County File No. PPR2048

DRAWN BY: O.E. WATTS	APPROVED BY:	REVISIONS 7-6-21 REVISED PER COUNTY REVIEW DEW	PROJECT 16965 LINDBERGH ROAD N1/2, N1/2, NW1/4, SE1/4, SEC. 22, T.11S., R.67W. EL PASO COUNTY	SHT. NAME GRADING AND EROSION CONTROL PLAN	SHT. NO. OF 2
DATE: 12-4-20	PROJ. NO.:	1-25-22 REVISED PER COUNTY REVIEW DEW			
DWG. NO.: 20-5449-04	DWG.:	8-18-22 REVISED PER COUNTY REVIEW DEW

DRAINAGE SWALE DETAIL
N.T.S.

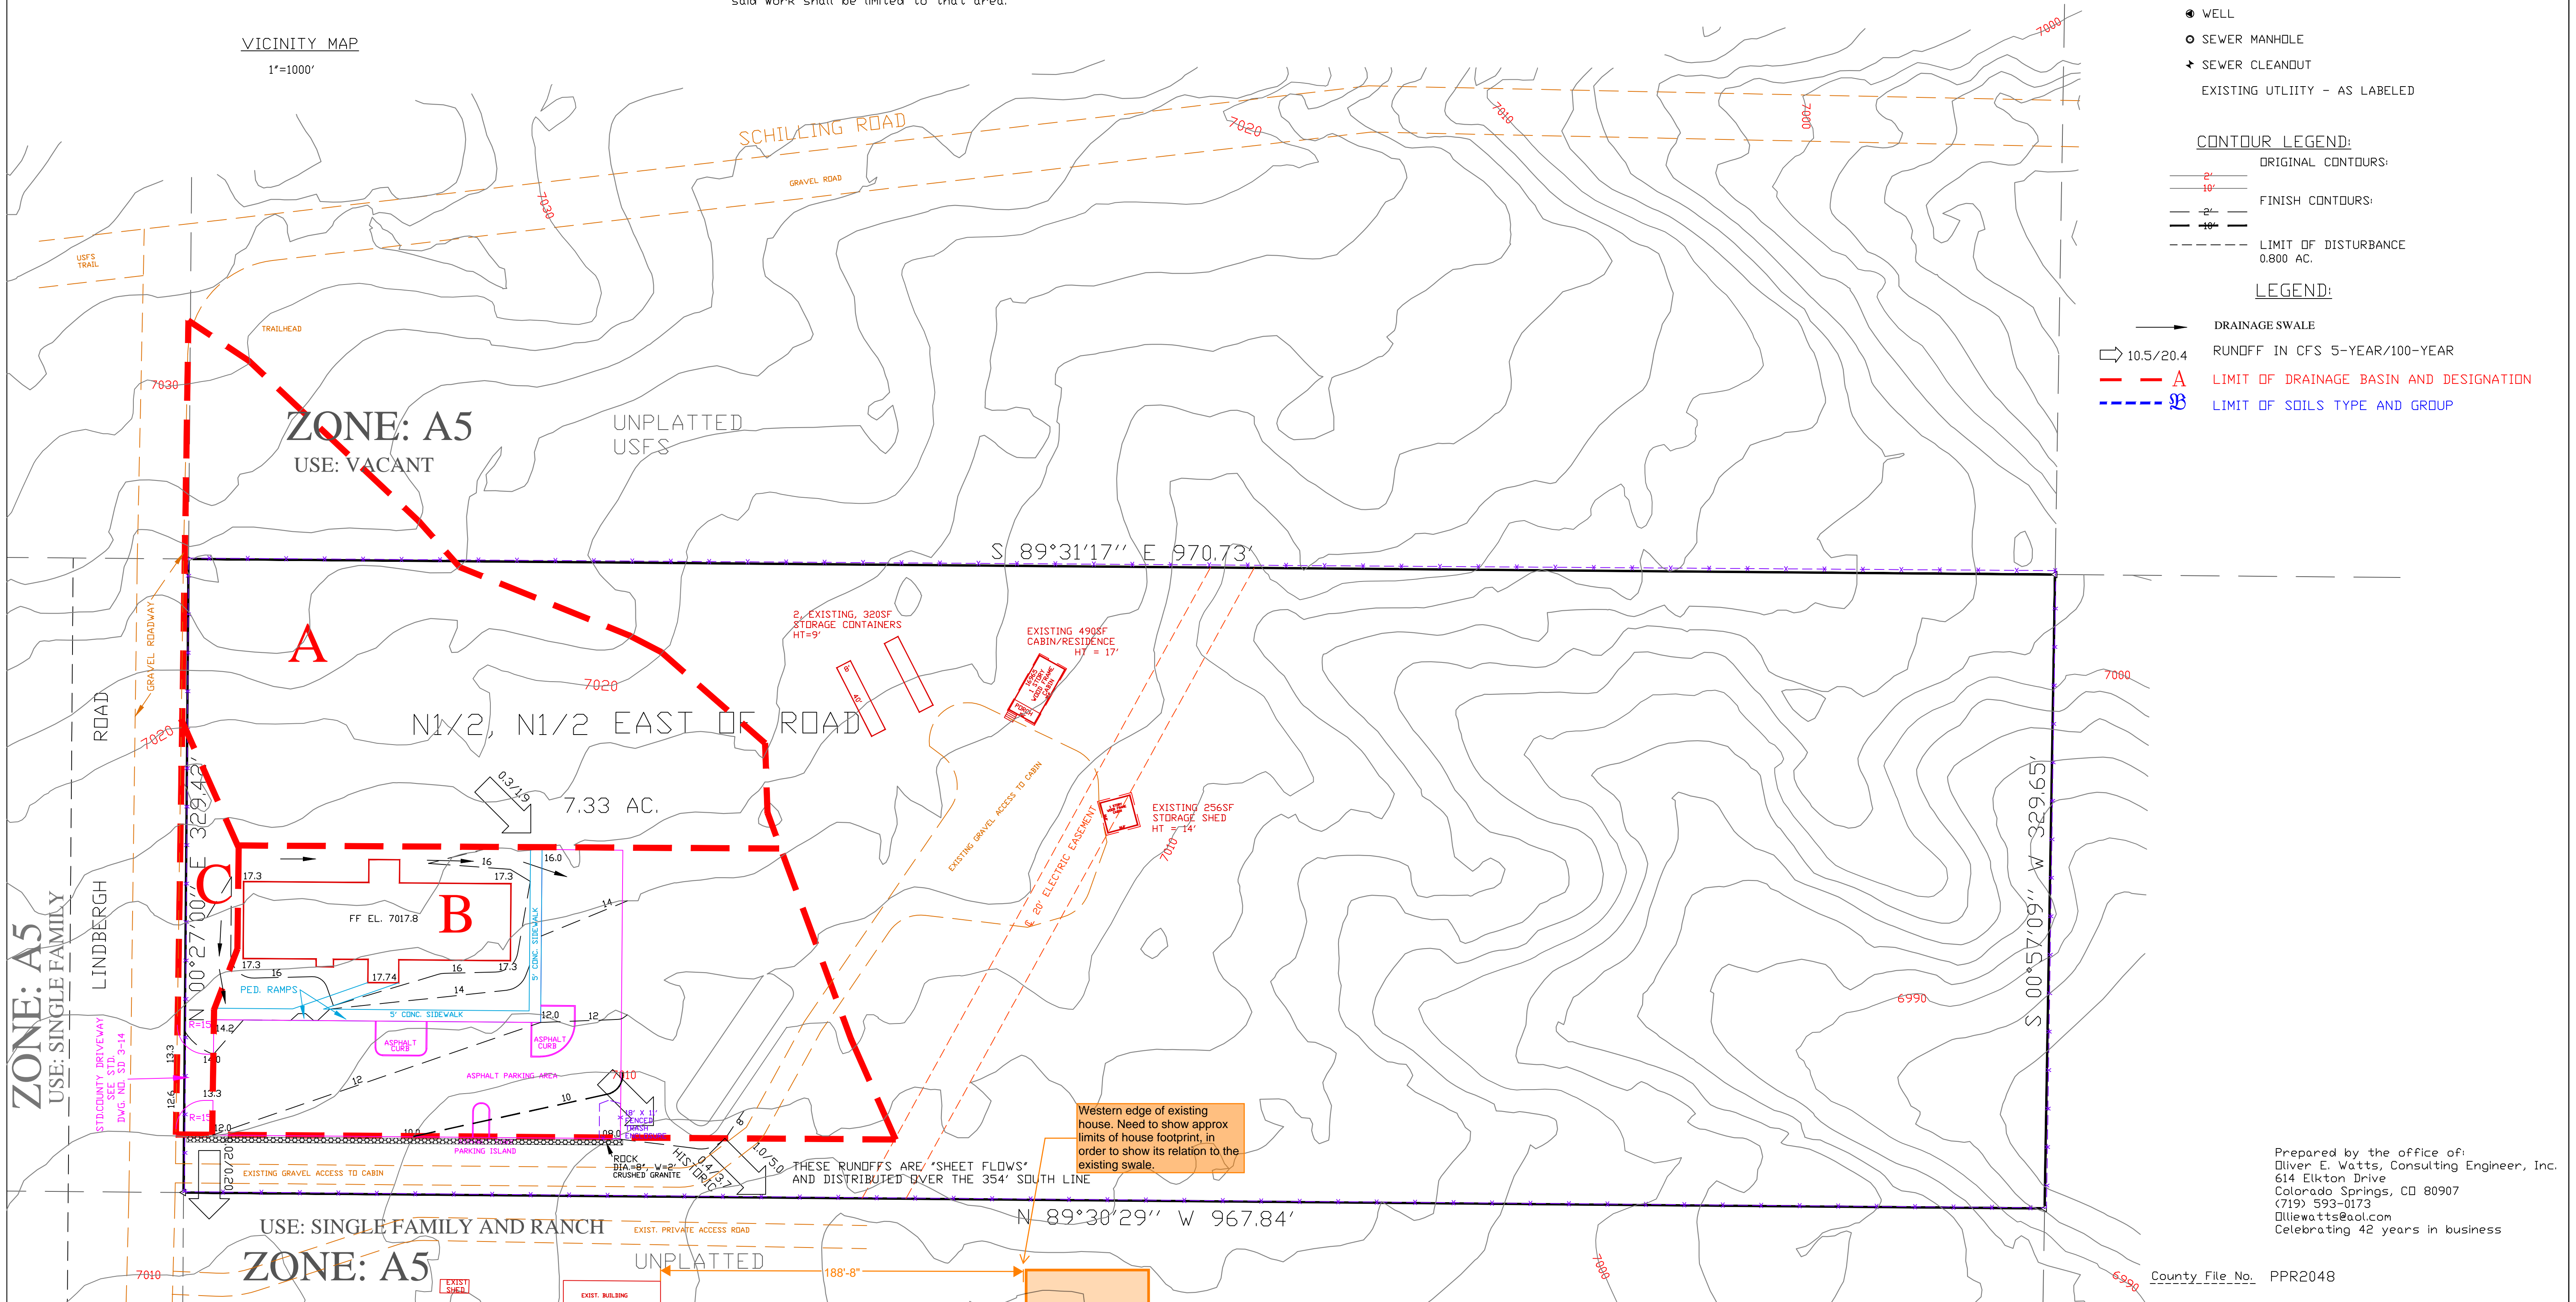
Does this detail still apply to this site now that the swale on the southern property boundary was removed? If not, remove this detail or revise it to apply to the small swales on two sides of the proposed building.

Western edge of existing house. Need to show approx limits of house footprint, in order to show its relation to the existing swale.

Per the response from the traffic engineer this access is to be removed. Please provide note that this will be removed and show any new access from within the site to the cabin. Include any proposed work within the limits of disturbance. Also, update the site development plan and drainage map accordingly

GEC Checklist Item W. Provide construction fencing, barricades, and/or signage at access points not to be used for construction. Provide section detail for this rock buffer, so installer knows to install rock below surface of asphalt. And specify/show the thickness of this rock buffer
